**KIRKLEES METROPOLITAN COUNCIL
INVESTMENT & REGENERATION SERVICE**

**DELEGATED DECISION TO DETERMINE APPLICATIONS FOR
CONSENT, AGREEMENT OR APPROVAL REQUIRED BY CONDITION**

Reference No: 2019/44/91067/W

Site Address: Broomfield House, Firth Street, Huddersfield, HD1 3DA

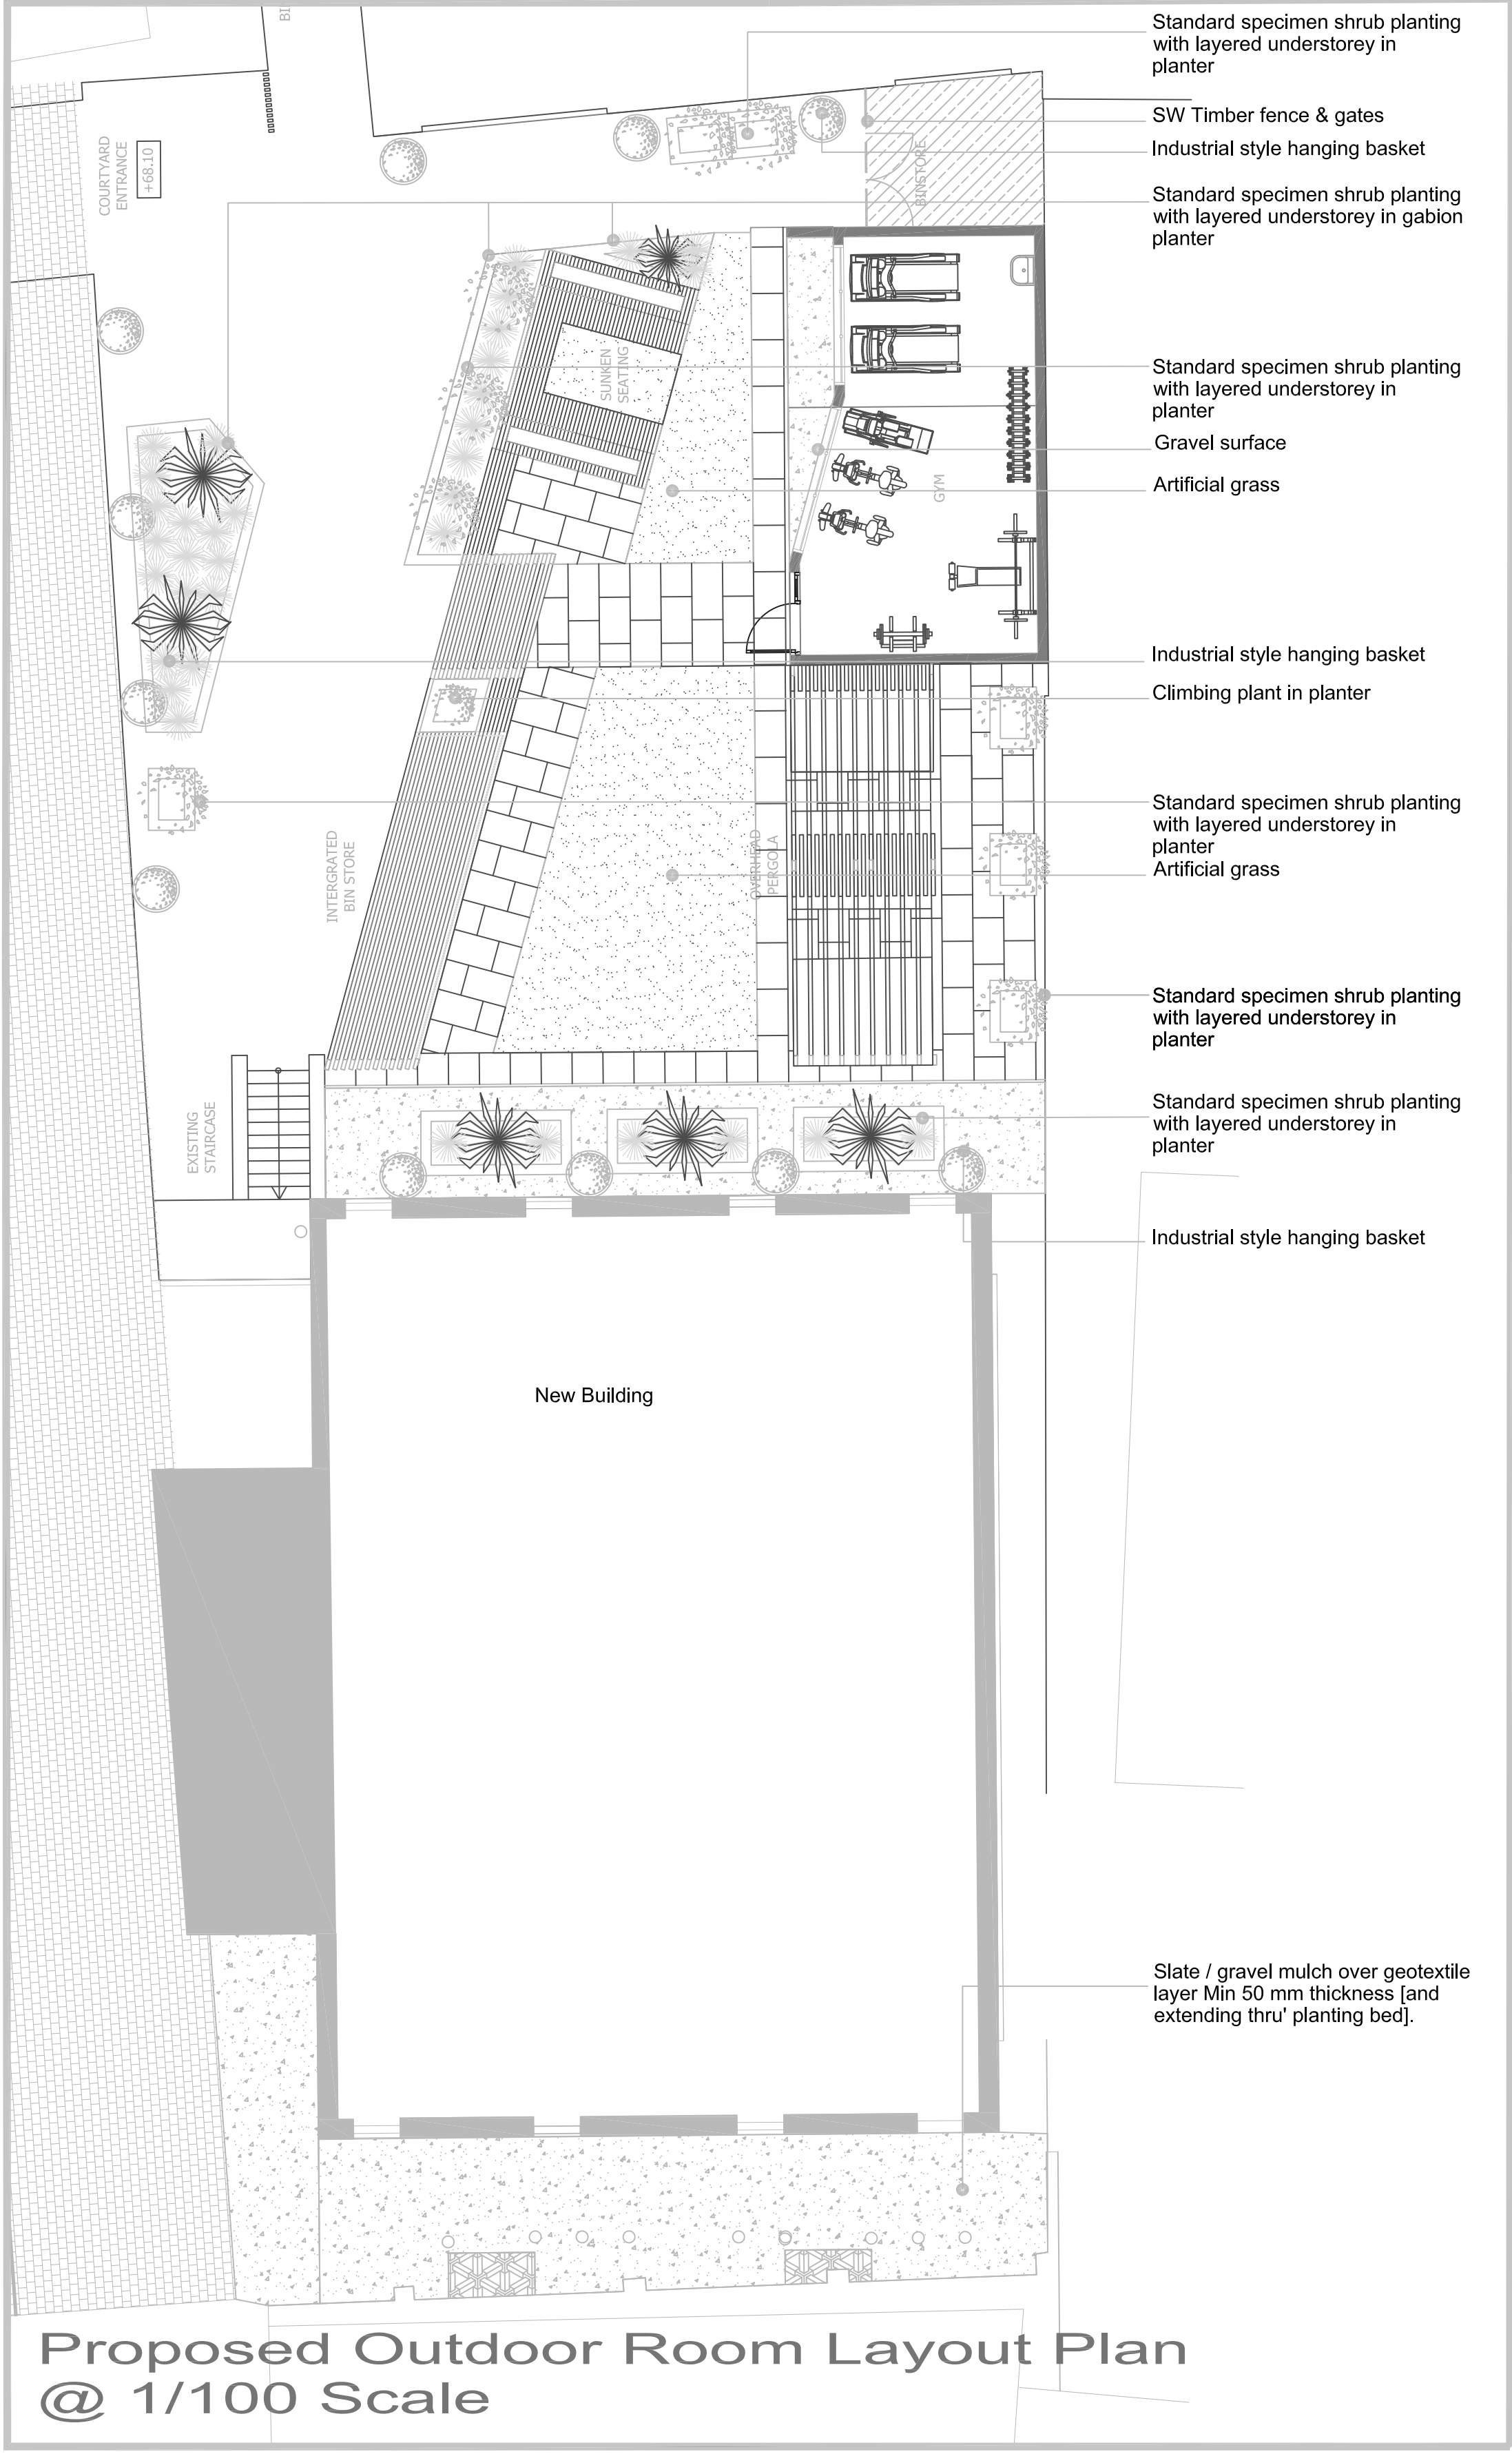
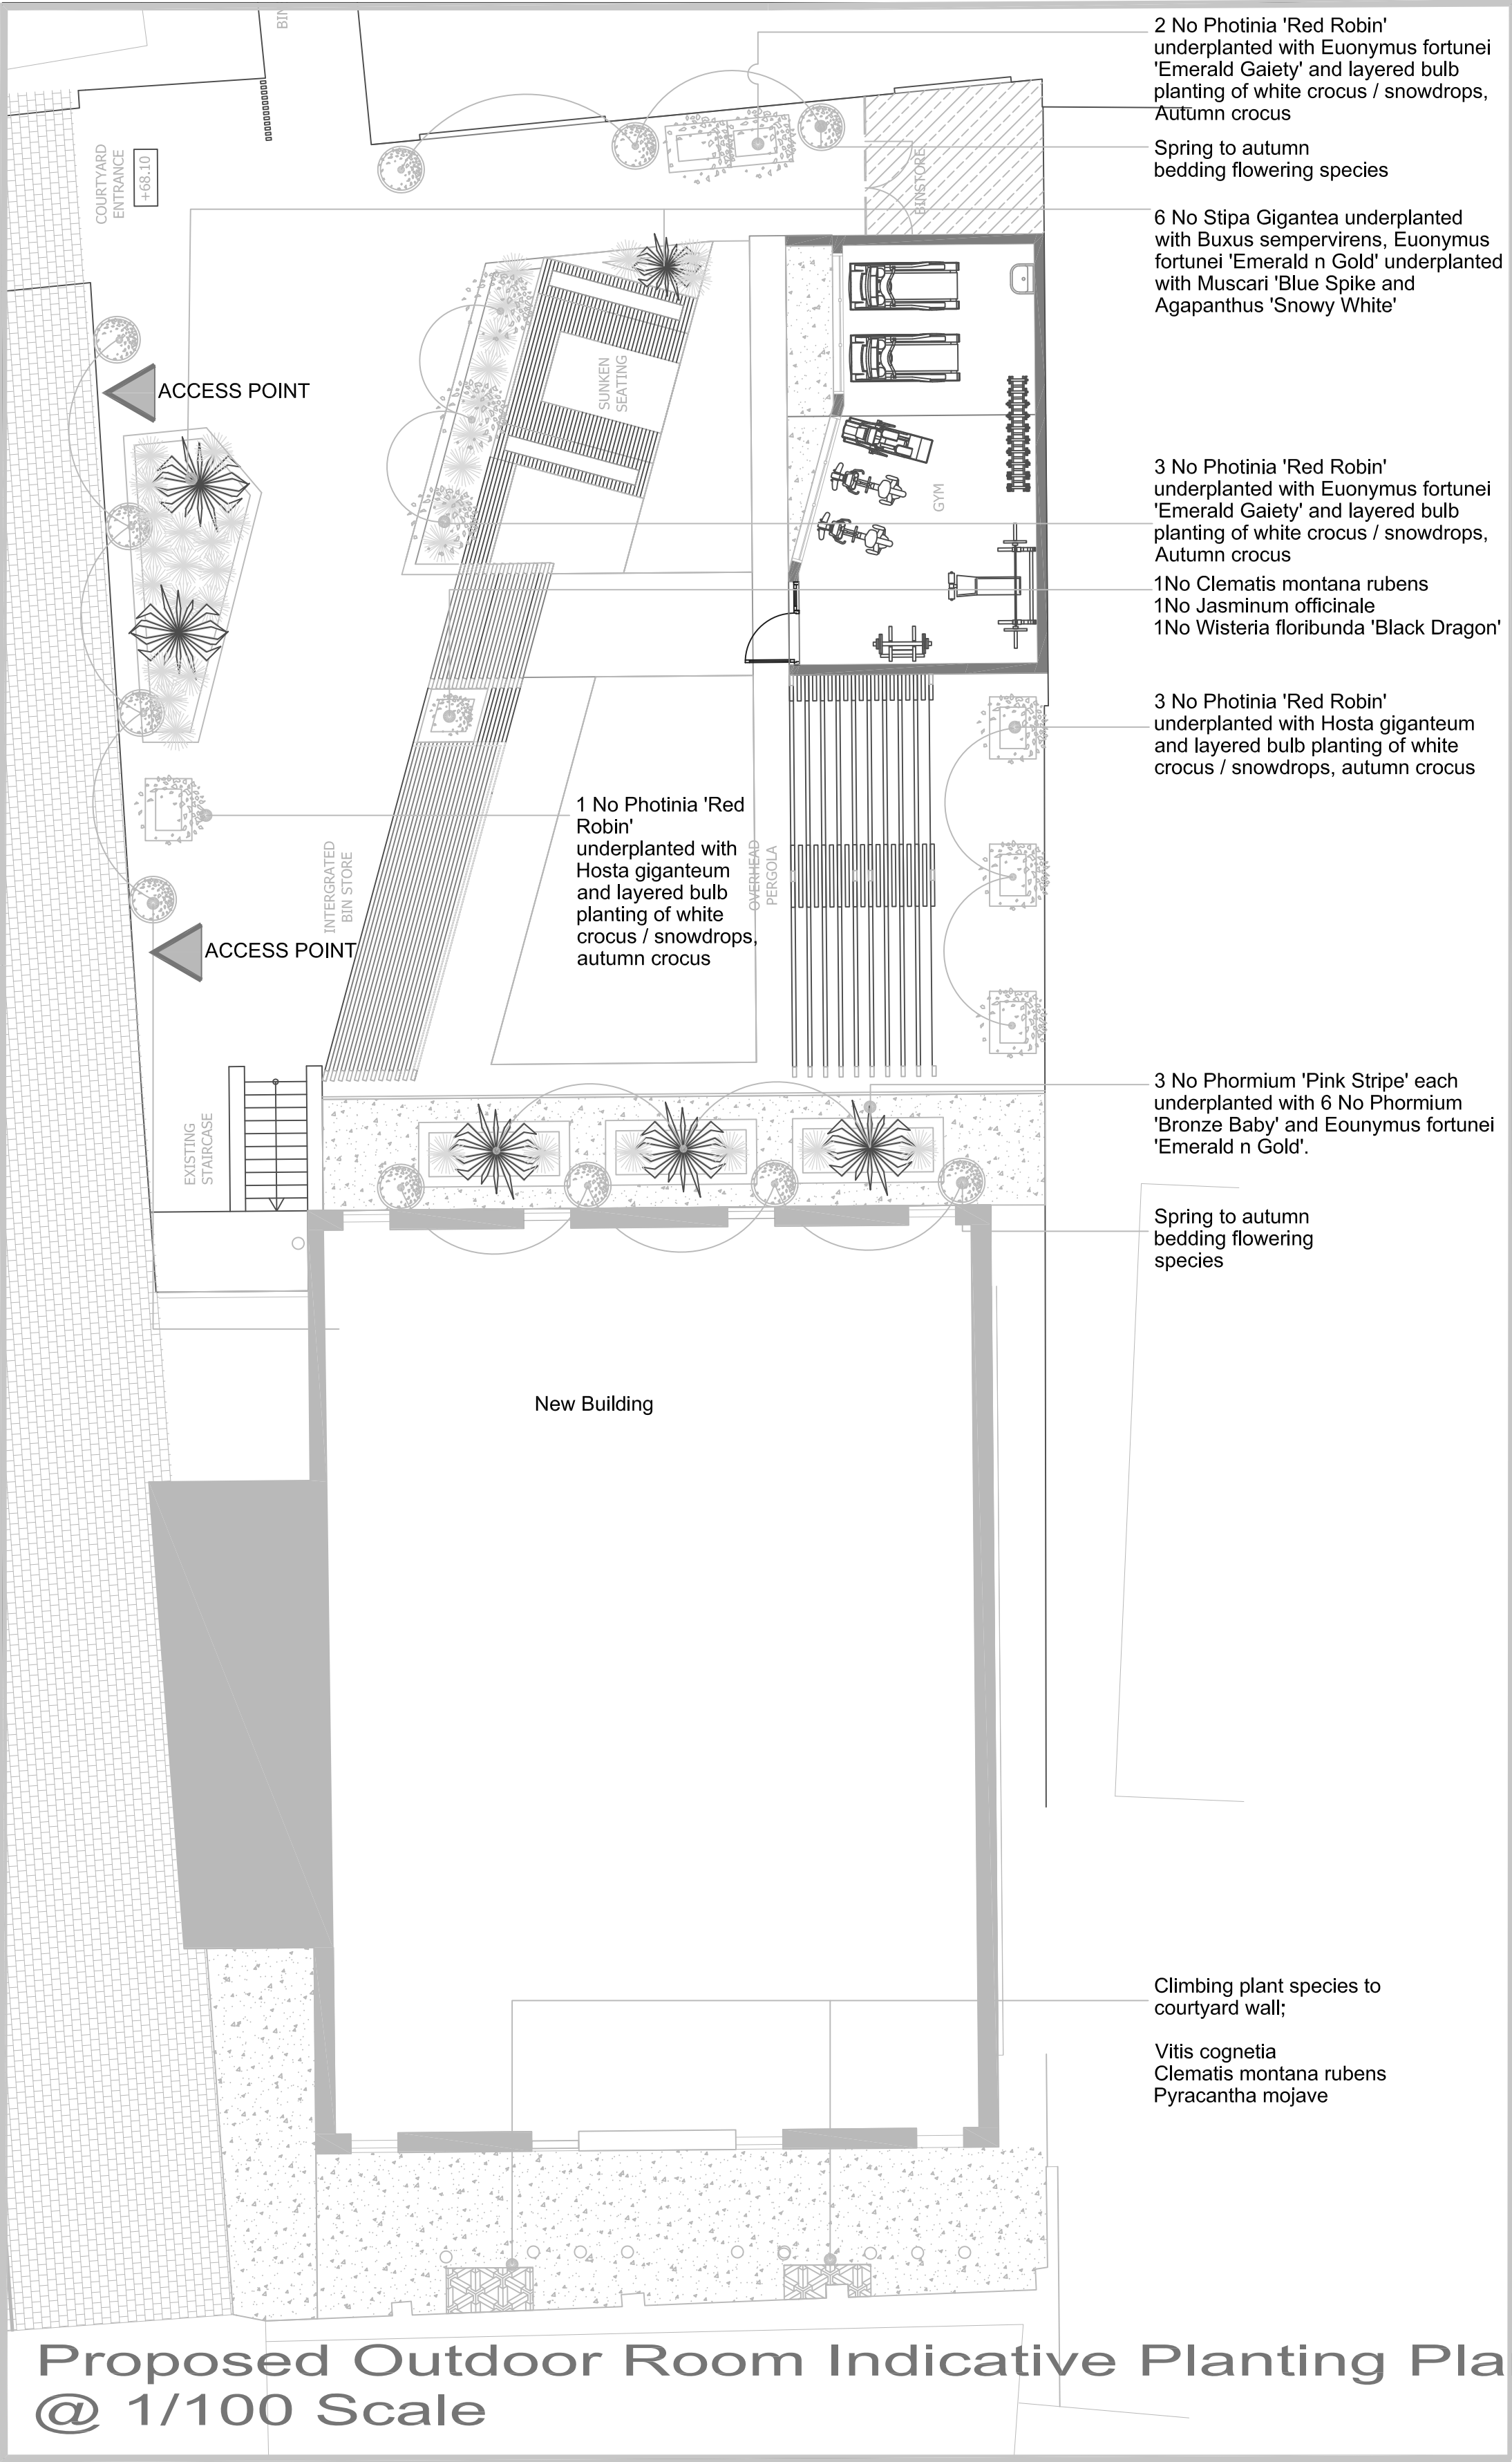
On 03/09/2019 the applicant submitted an amended landscape design drawing (100.081.05) which shows a similar layout to the earlier drawings, but includes soft planting in planters and hanging baskets. Species are specified, and these would provide year-round visual interest.

Proposed ground materials include sandstone paving, slate mulch and gravel. These are appropriate materials for this site. Artificial grass is also proposed for some areas within the courtyard – this is a poor quality ground treatment, but as only relatively small areas would be covered with it, it is not recommended that approval be withheld due to its inclusion in the proposals.

The proposed seating area and pergola would add amenity to the outdoor space and can be approved under this application. The proposed gym is not a landscaping feature, and is a single-storey structure that would require a separate approval.

Condition 2 – The landscaping details shown on drawing 100.081.05 are considered acceptable for the purpose of condition 2. Condition 2 will be discharged upon construction and completion of the development in
